PORTLAND MAINE

April 12, 2010

RE: 461 Woodford Street – 176 B003 – R-5 – illegal deck – permit #08-0249

## 459-461 Woodford

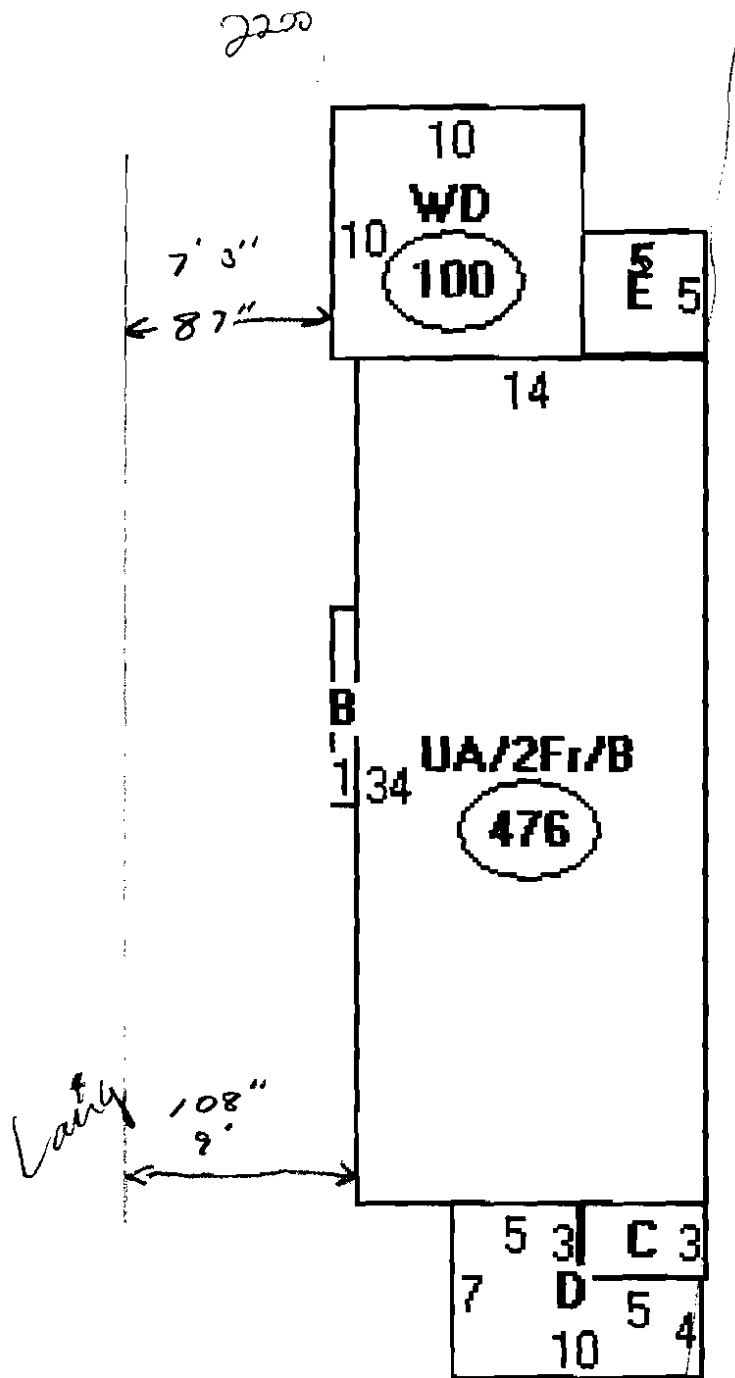
On March 19, 2008, you applied for a permit (#08-0249) to build a roof over an existing deck at the rear of your building at 461 Woodford Street. In reviewing the application, I found that the original deck had not been permitted when it was built. It could not be permitted “after the fact” because it did not meet the minimum required side setback of eight (8) feet [section 14-120(1)(d)(3)(a)]. It also could not be permitted because it did not meet section 14-388 which stated that “a building nonconforming as to the regulations governing area per dwelling unit shall not be enlarged unless such building including such addition or enlargement, is made to conform to all the area per dwelling regulations of the zone in which it is located.” The minimum land area per dwelling unit requirement is 3,000 square feet in the R-5 zone [section 14-120(1)(b)], and your lot size is 2,200 square feet.

You need to bring your property into compliance. The City Council repealed section 14-388 on January 4, 2010. You need to apply for a building permit to permit the deck “after the fact”. The deck must meet the requirements of the R-5 residential zone including the eight (8) side setback. You have thirty days to apply for the permit for the deck or remove it.
